Our Ref: K/29/17/PL 16-08-2017

Demolition of existing dwelling to create 1 No. new dwelling.

14 Coastal Road Kingston

Thank you for your internet representation made on 25th September 2017 which has been recorded as '**an objection**' with the comments as follows:

DRAWING
PROPOSED SITE PLAN

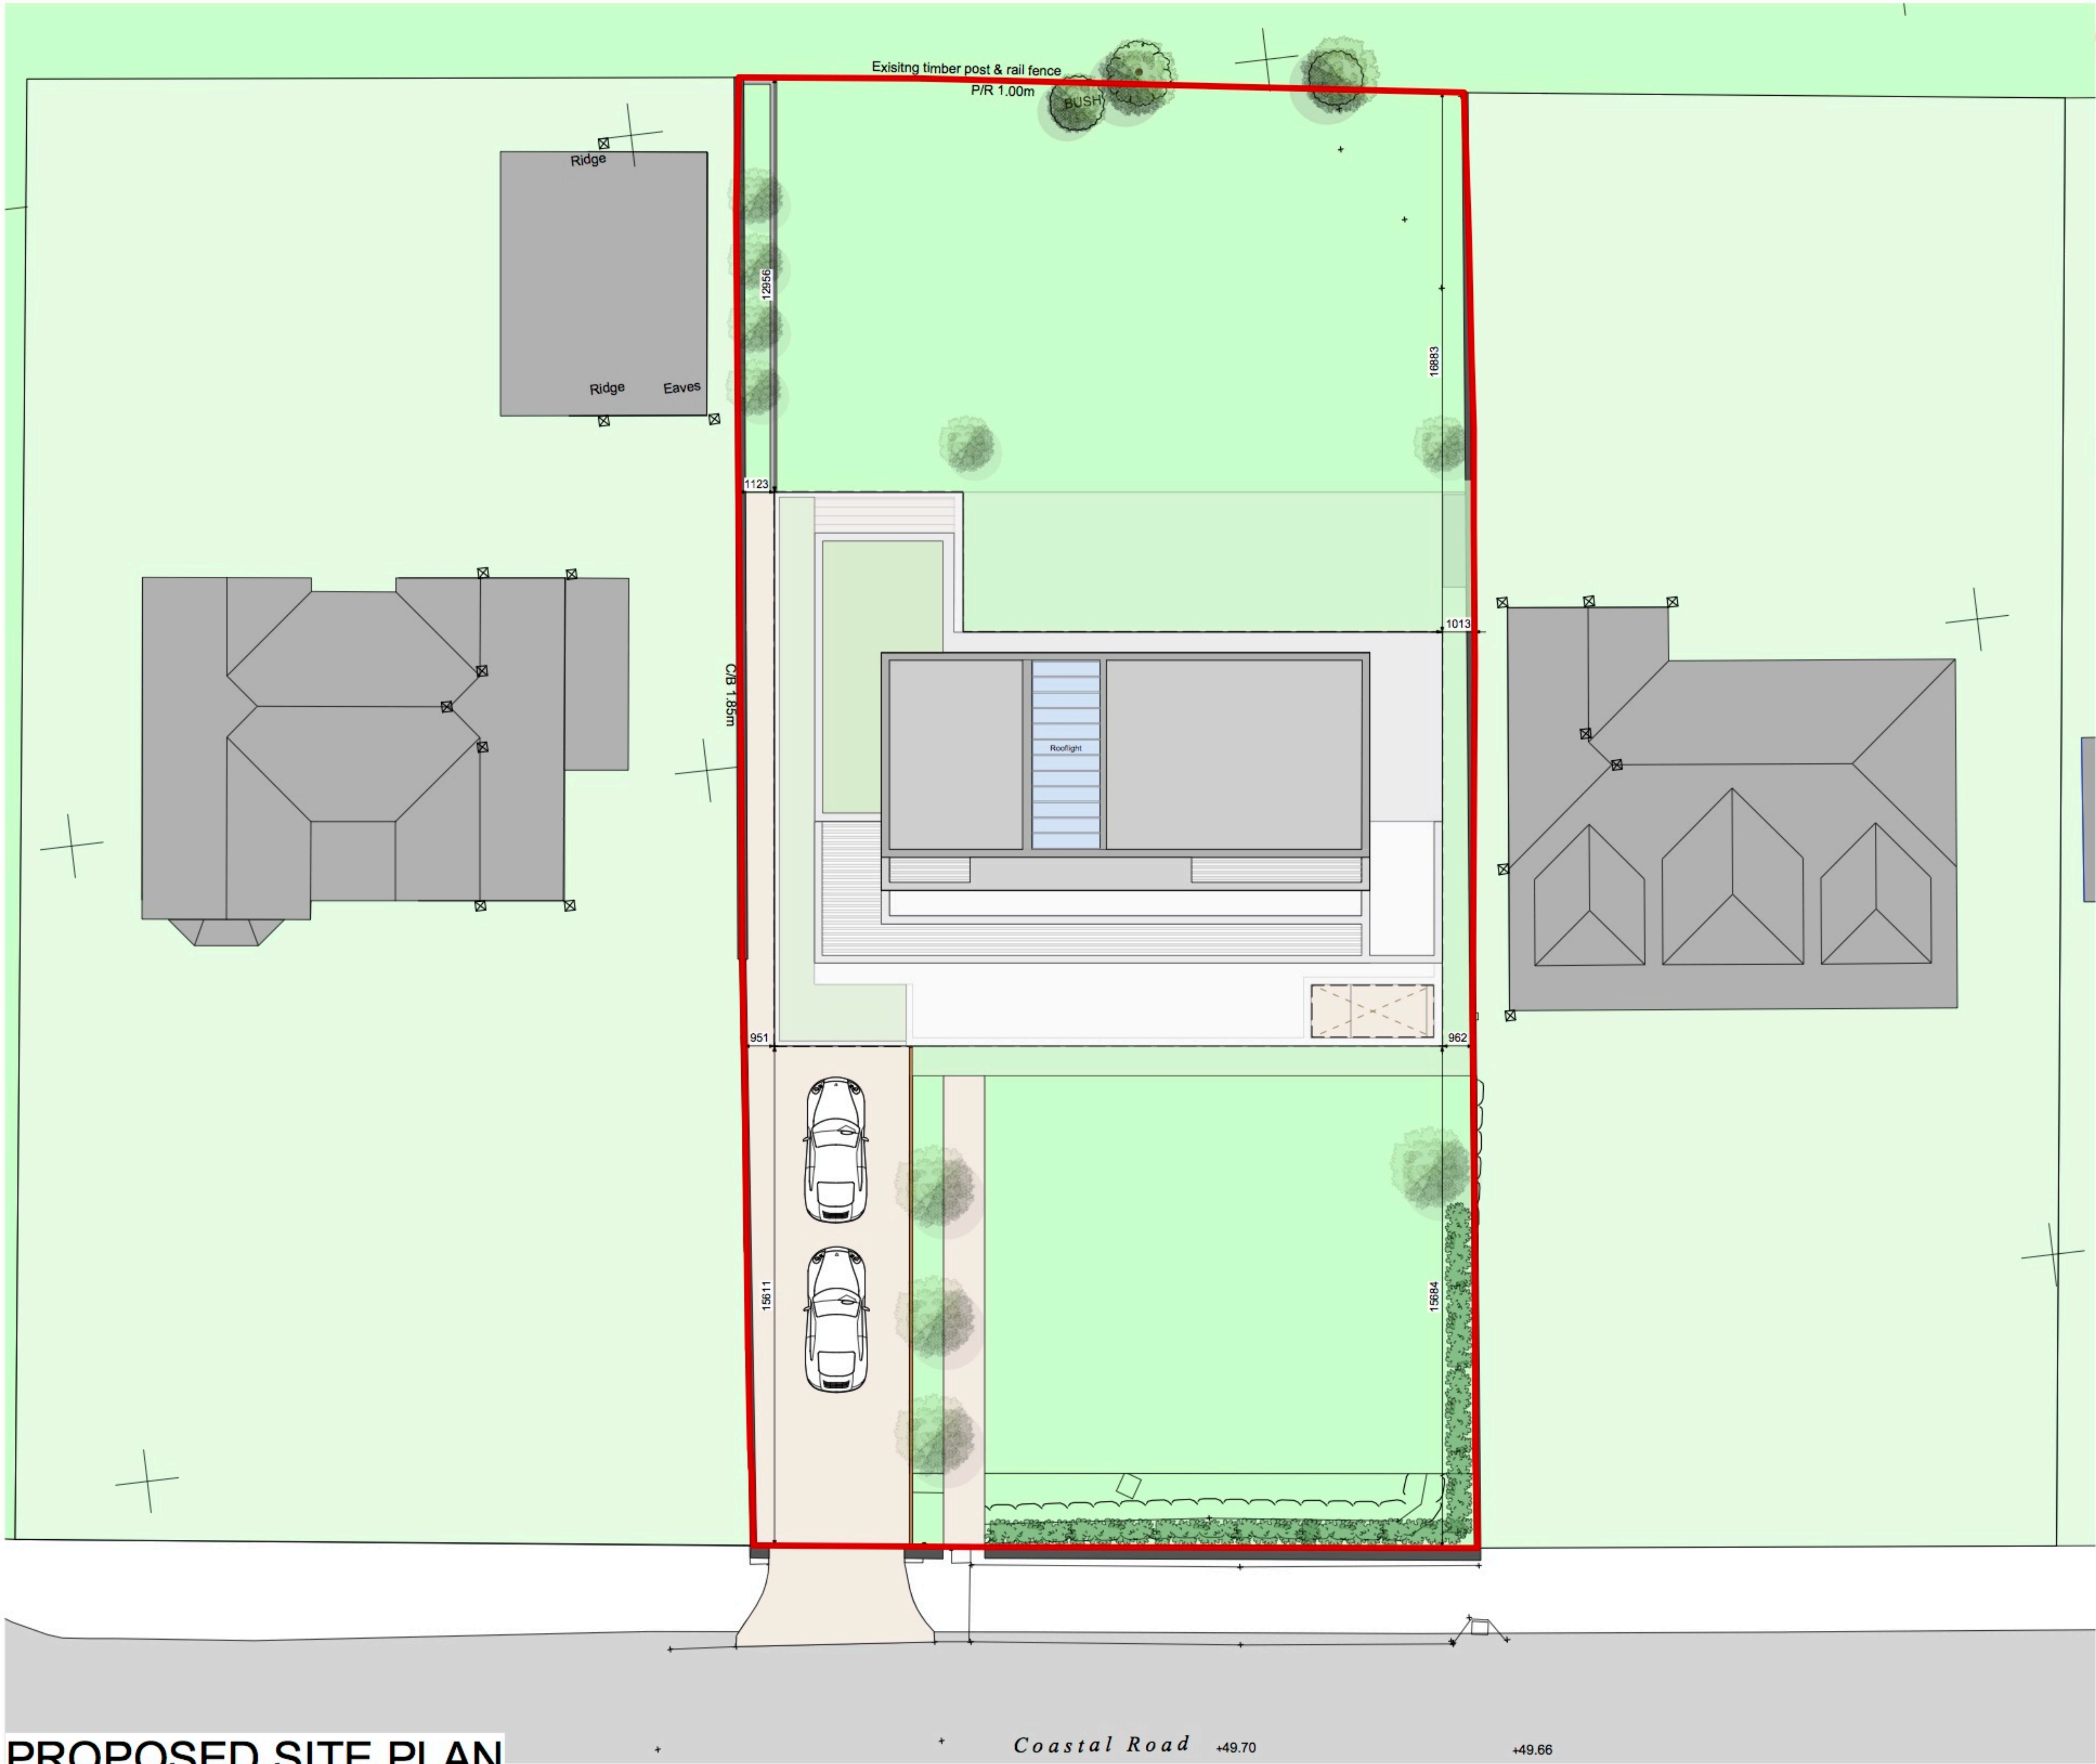
1) The distance between the new house and our boundary wall. We do not consider that this distance should be measured to our house wall, but rather our boundary wall. This new proposal in fact brings our houses closer together. This is unlikely to be in either of our interests.

PROPOSED FIRST FLOOR PLAN

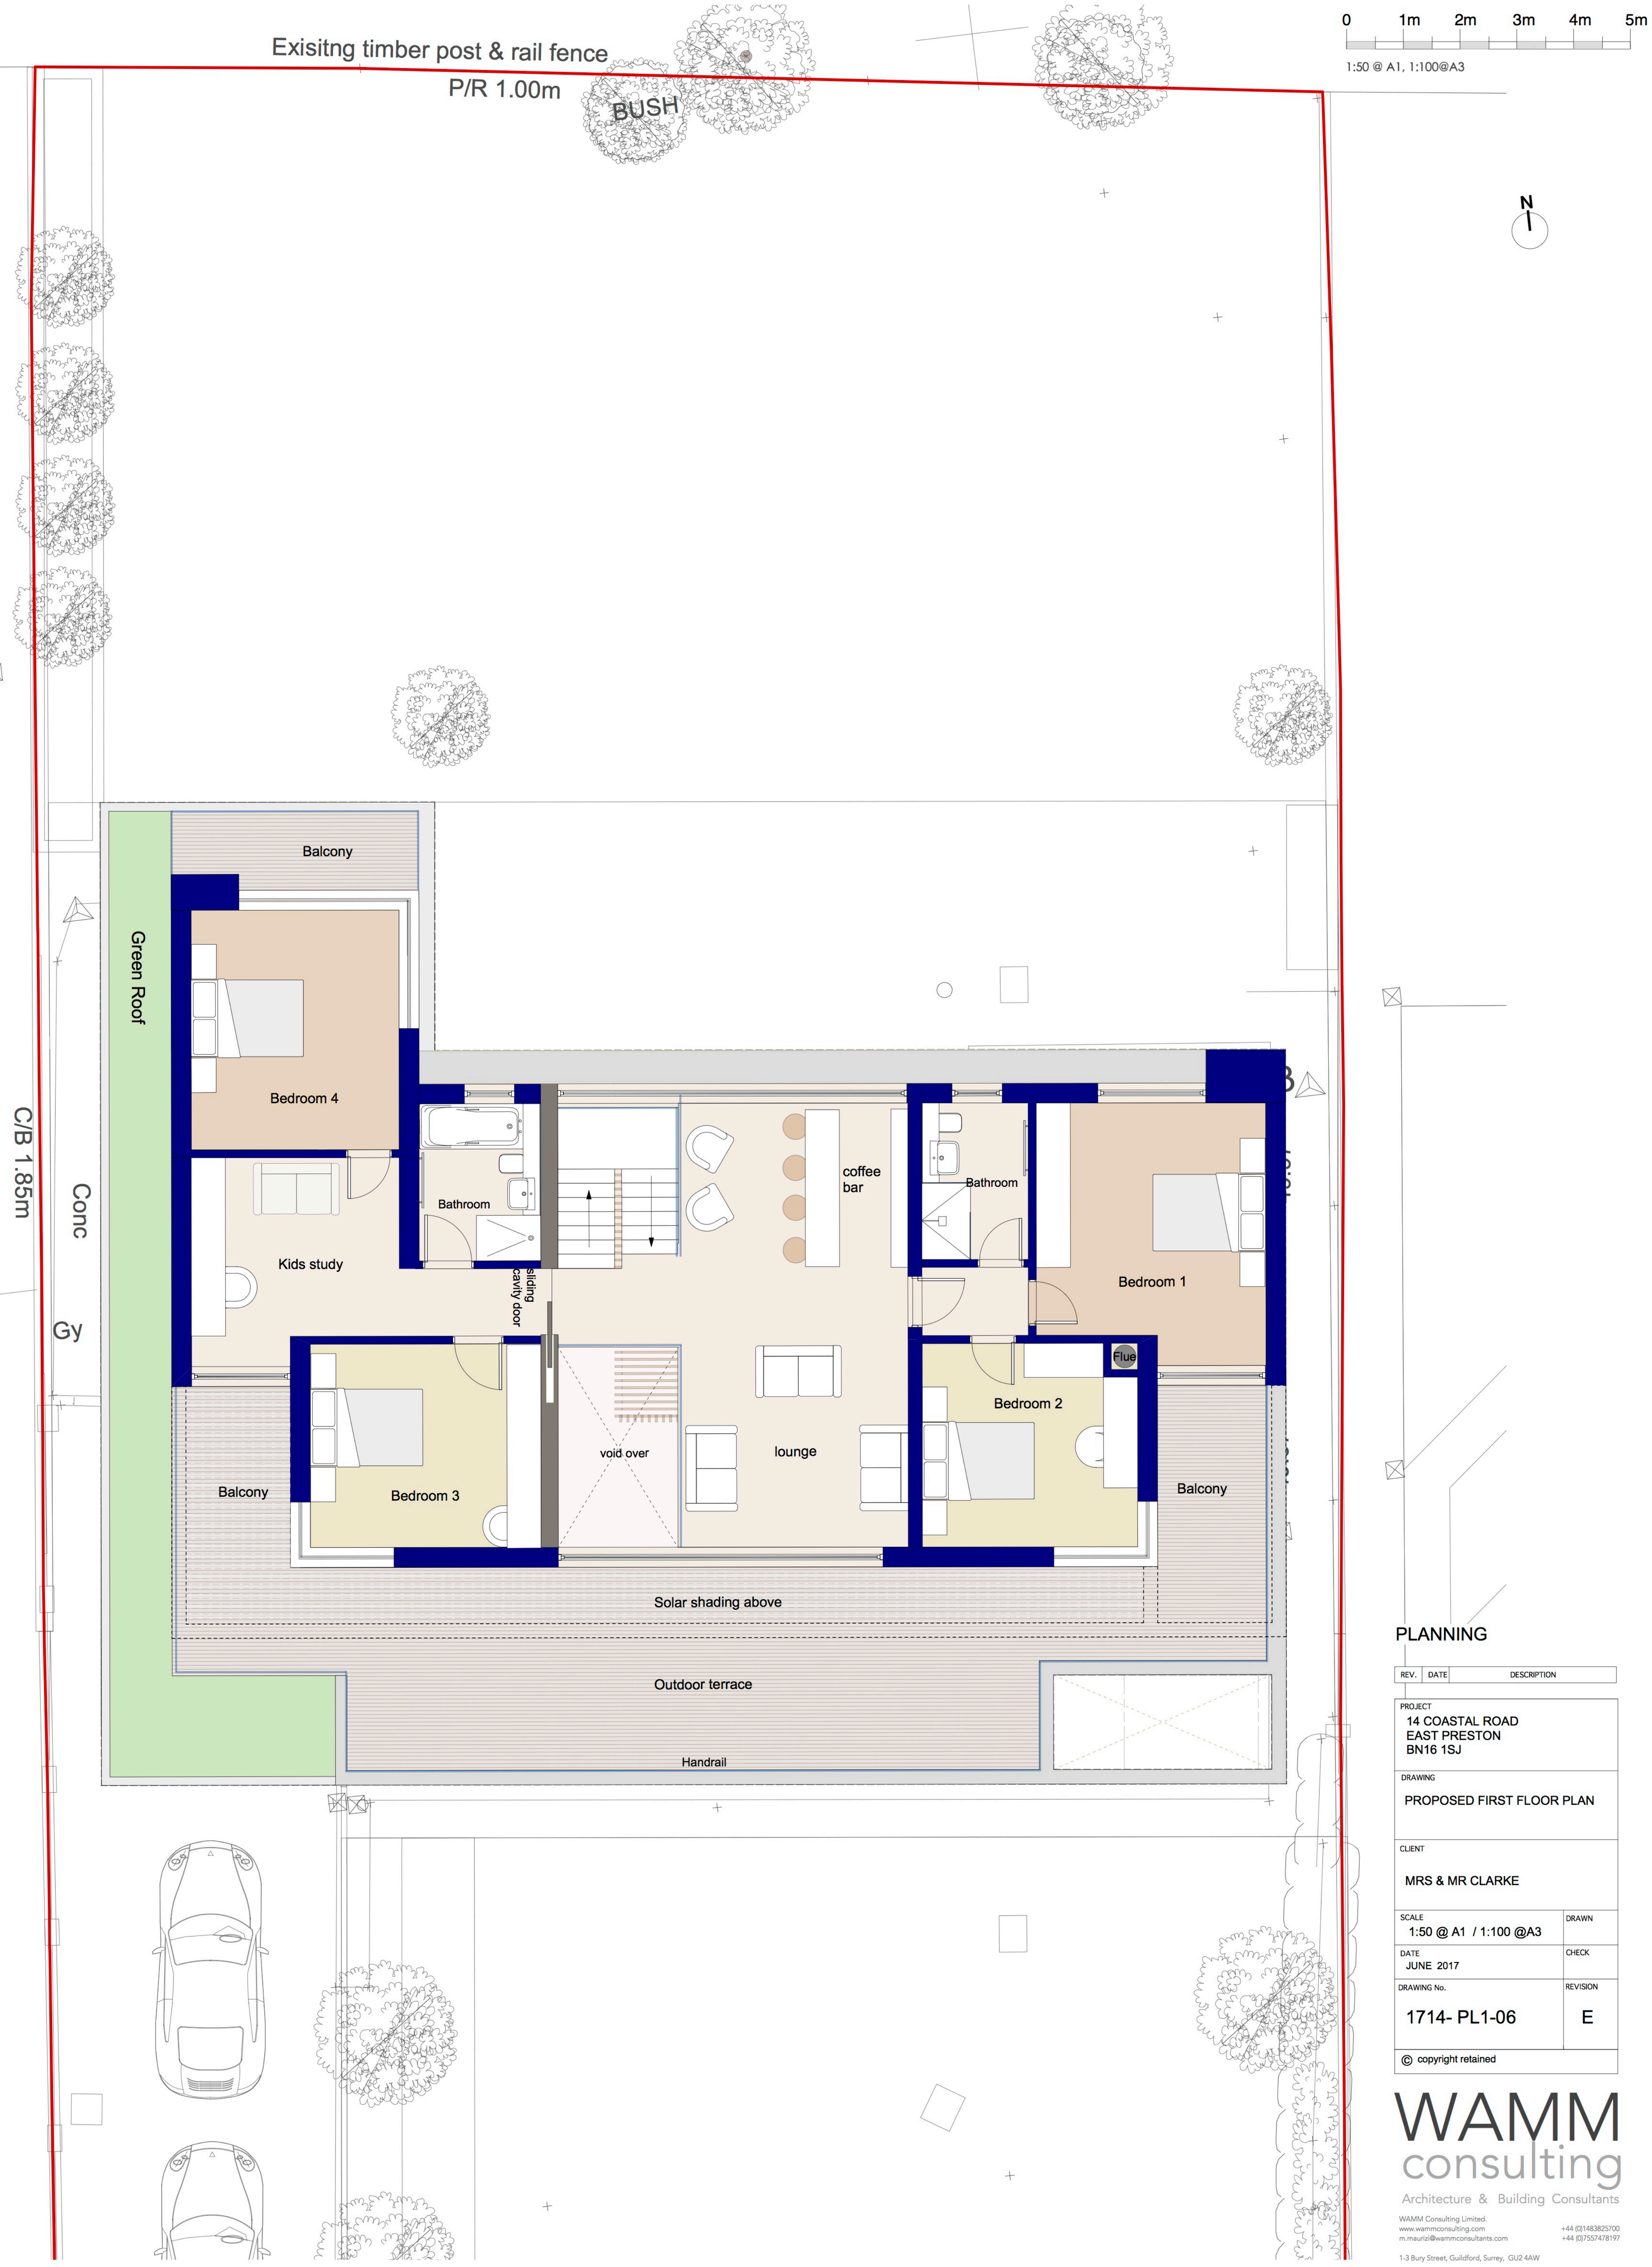
2) We are concerned that the balconies (particularly a new second floor terrace) will cause our garden to be overlooked and impinge on our privacy. Whilst there is already a balcony on the first floor, we do not think that the privacy we should be afforded in our garden has been adequately addressed.
